Recommendation Report for Planning Permission

REF NO: BR/76/19/PL

LOCATION: Alloways
33 Shelley Road
Bognor Regis
PO21 2SN

PROPOSAL: Conversion of existing house into 2 No. 3 bed semi detached properties.

No.	Revision/Issue	Date
Proposed Conversion Proposed Elevations Planning		
Date March 2019		
Scale 1:50

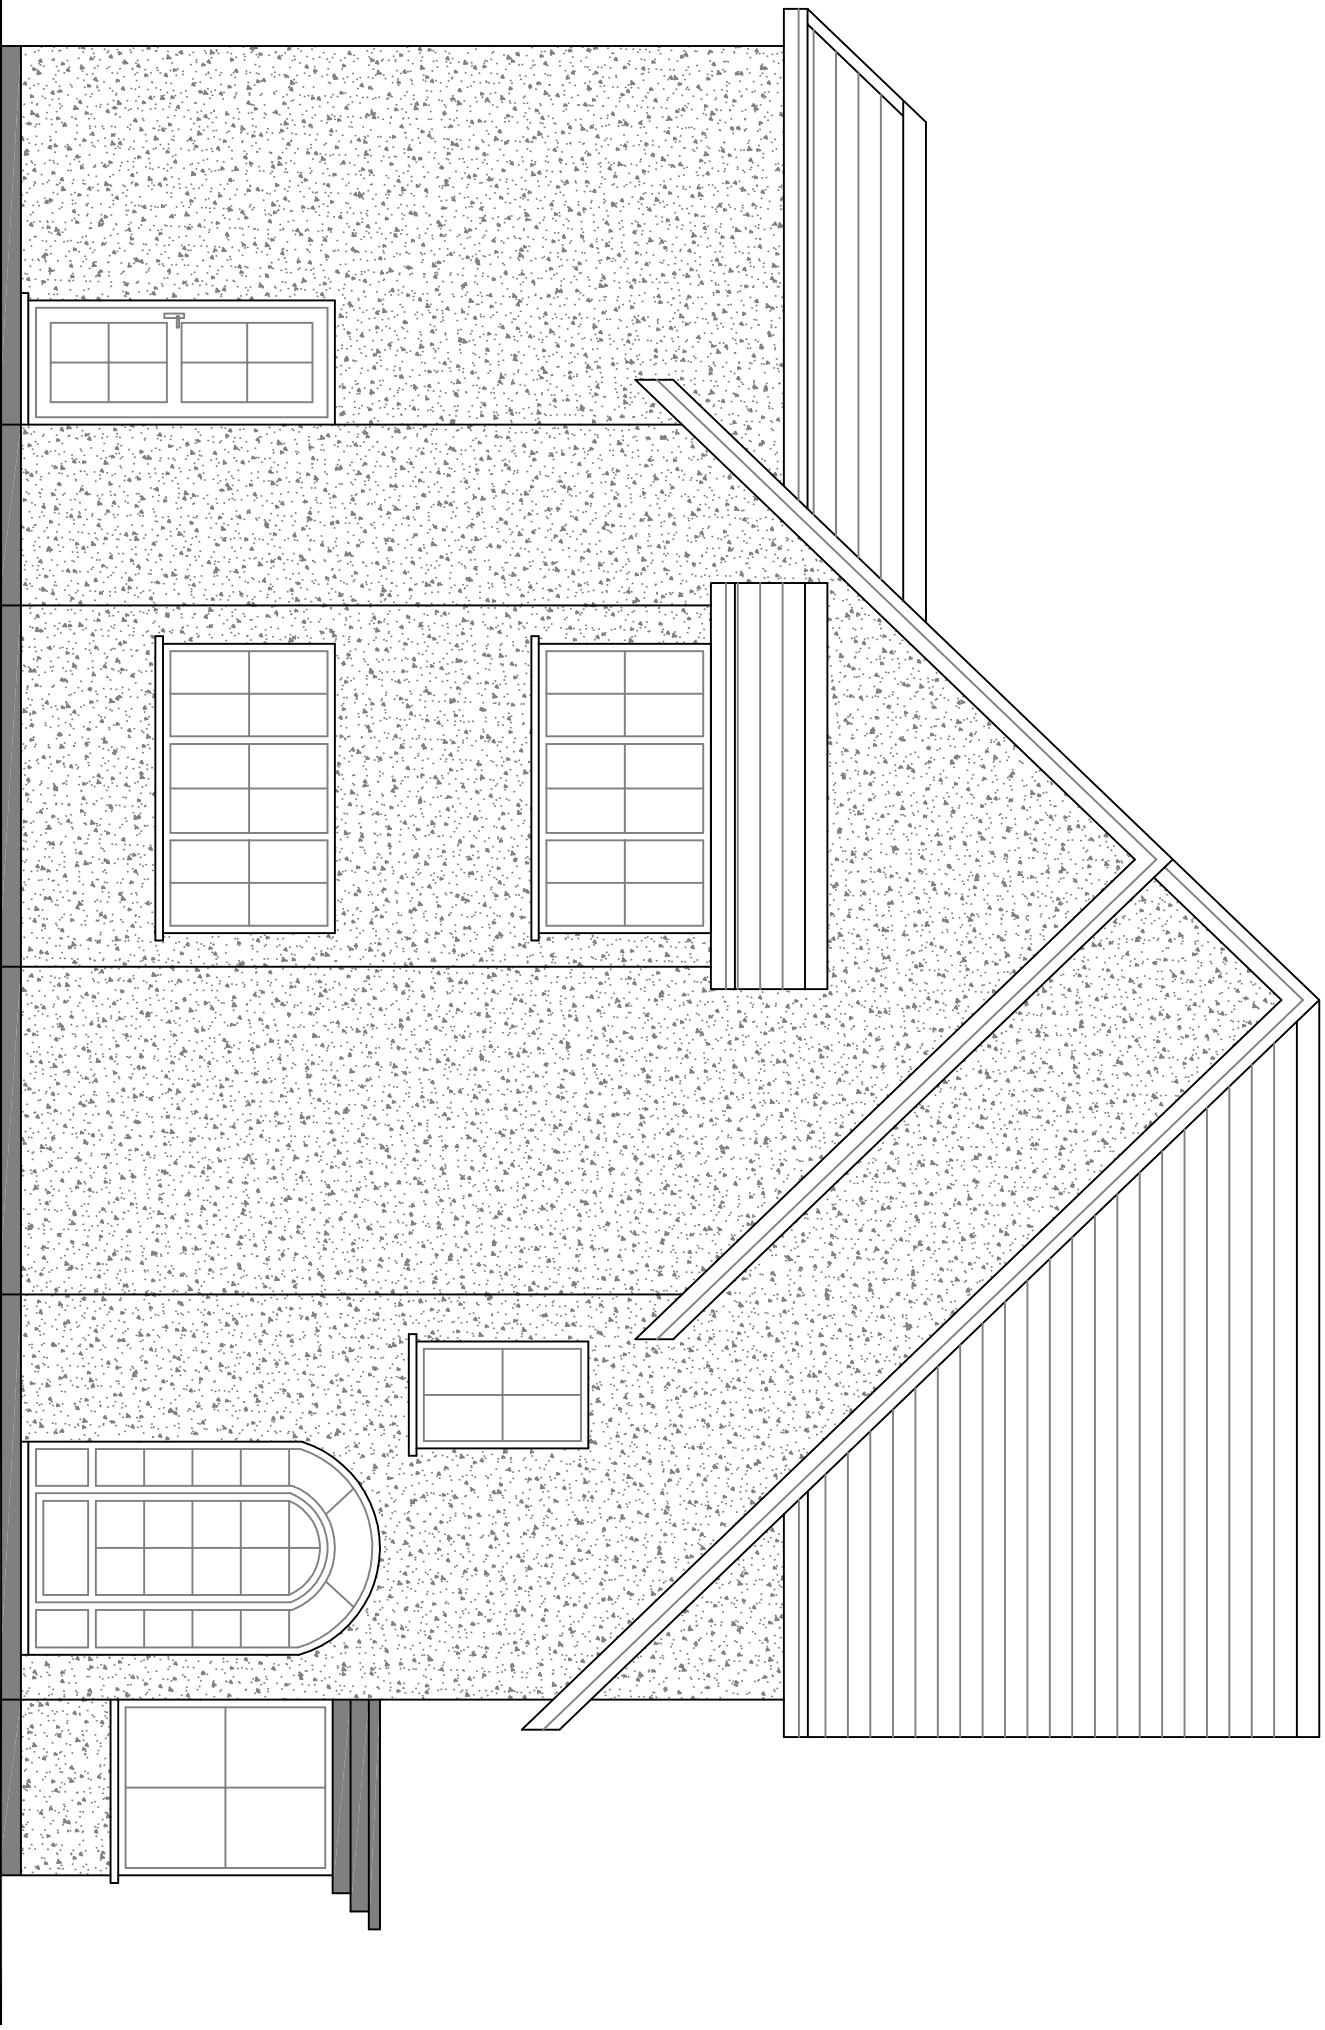
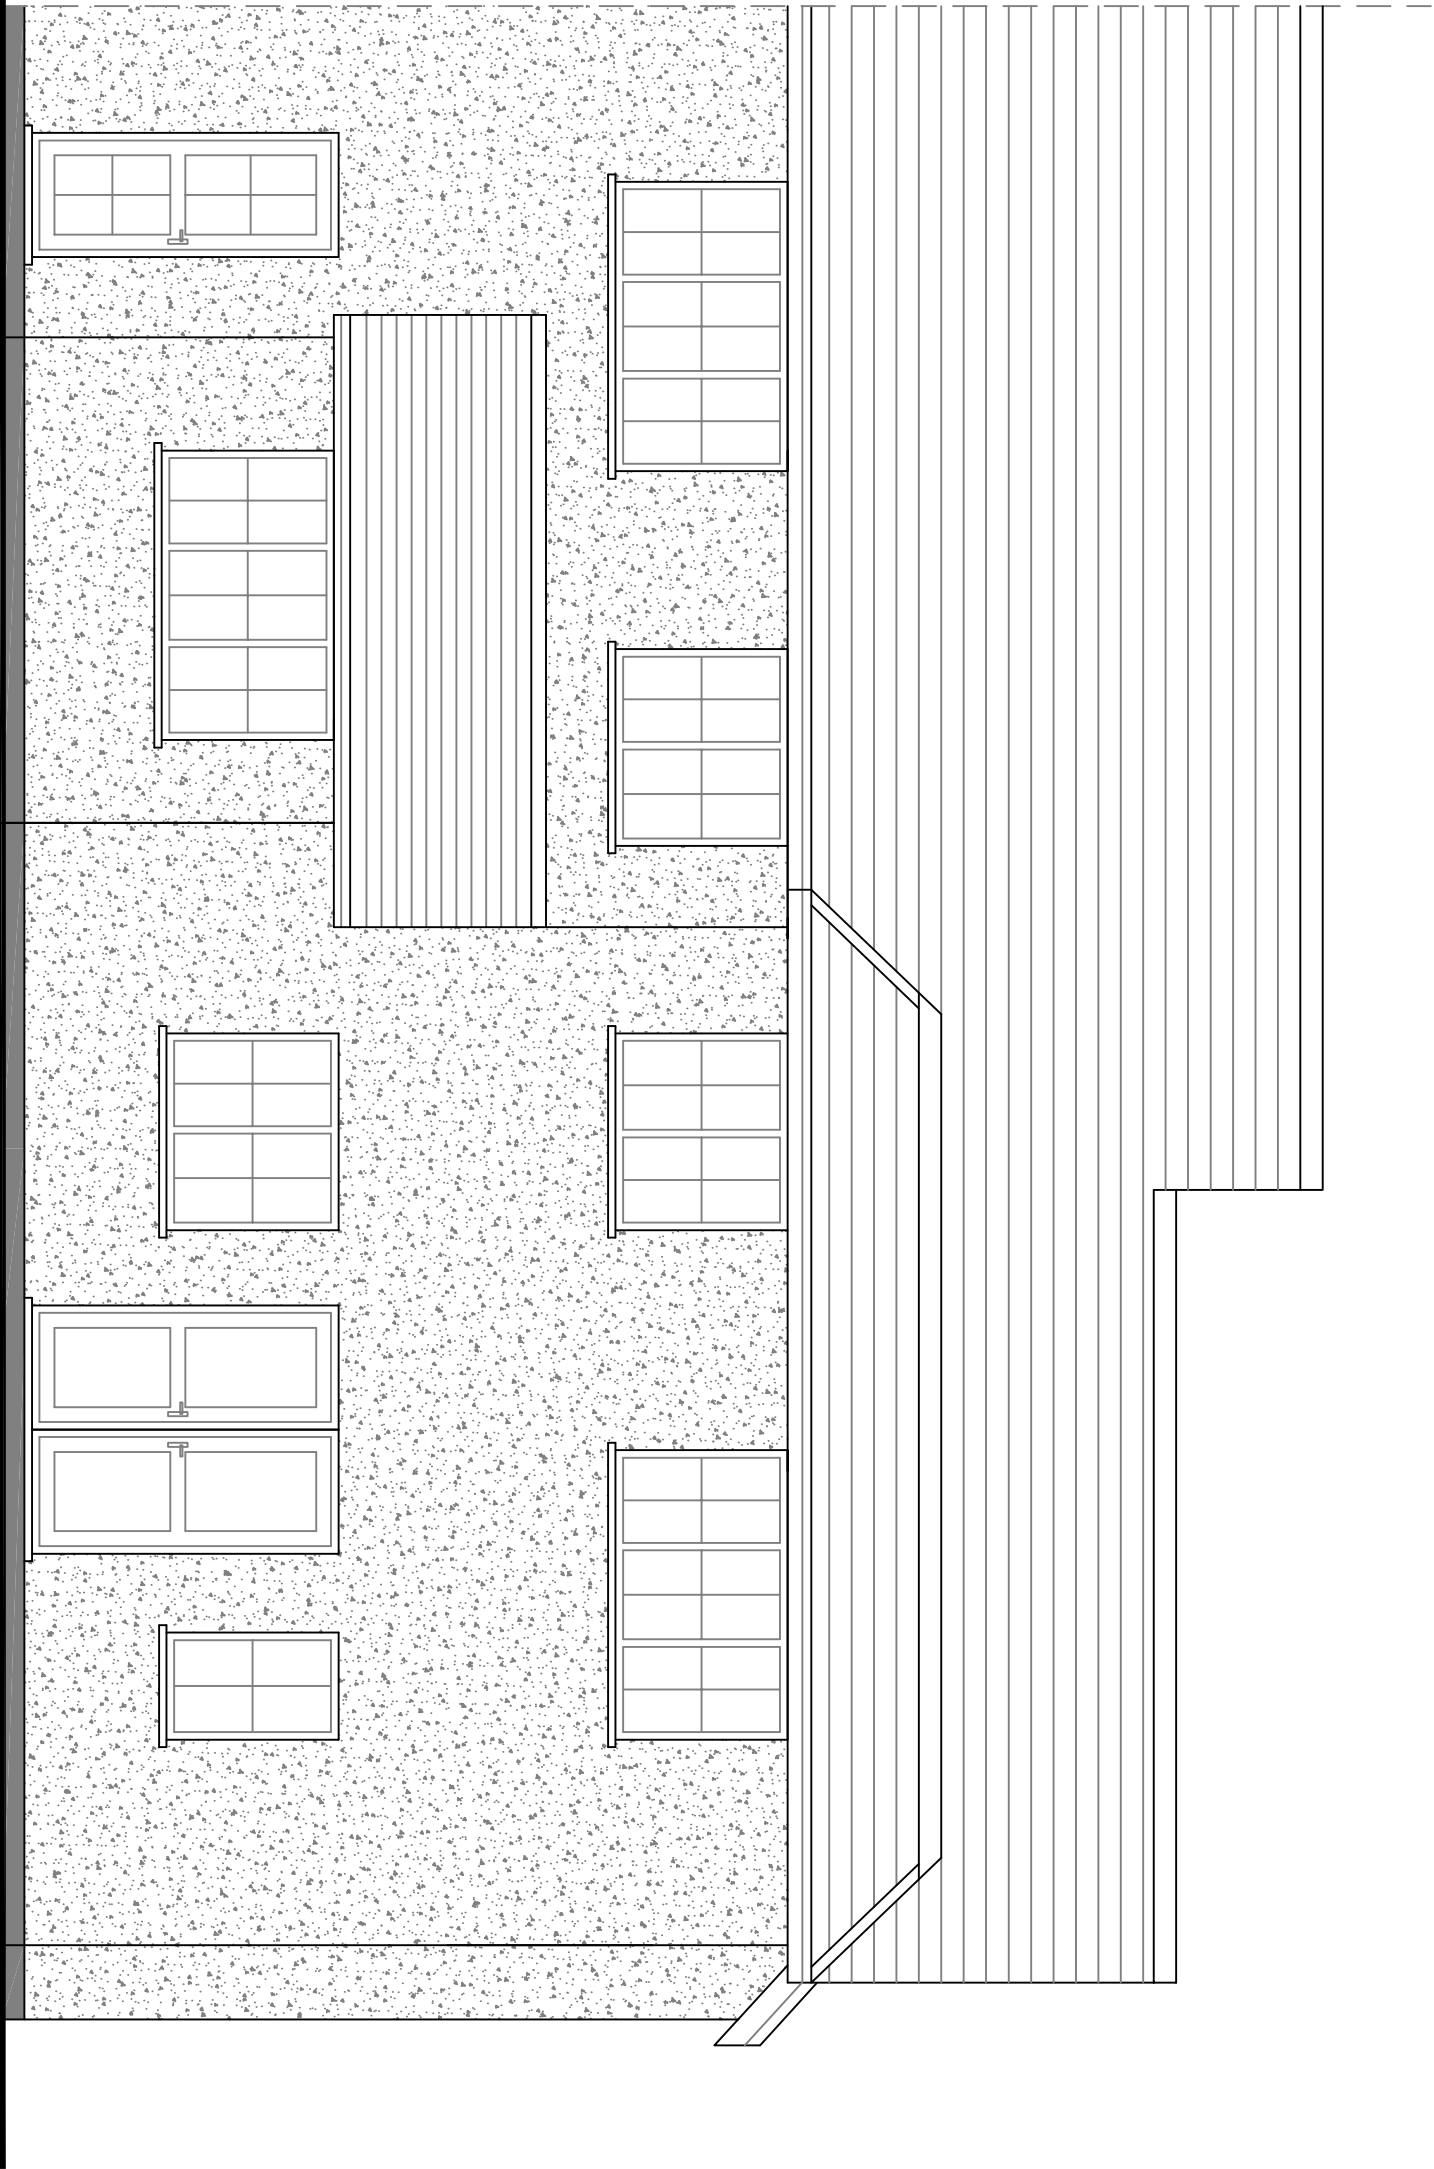
Officers note the objections raised, in particular by the occupiers of adjoining property 31, where there is concern that there would be detrimental loss of light to their kitchen as a result of the rear first floor extension.

It is considered that the proposed resultant 2 storey rear extension would have an impact on the occupiers of adjoining properties 31 and 33 also part of this application. Particular regard should be had with impact of the proposal on the occupiers of adjoining property 31, where it is considered that the proposed rear extension would have an overbearing impact particularly when viewed from the windows (kitchen) in the side elevation of number 31. It is considered that while the rear extension (1st floor) would have an overbearing impact upon the occupiers of adjoining properties, given its depth and separation distance, it would not be to such a level that refusal of the proposal would be warranted. Therefore, it is considered that the proposal is acceptable.
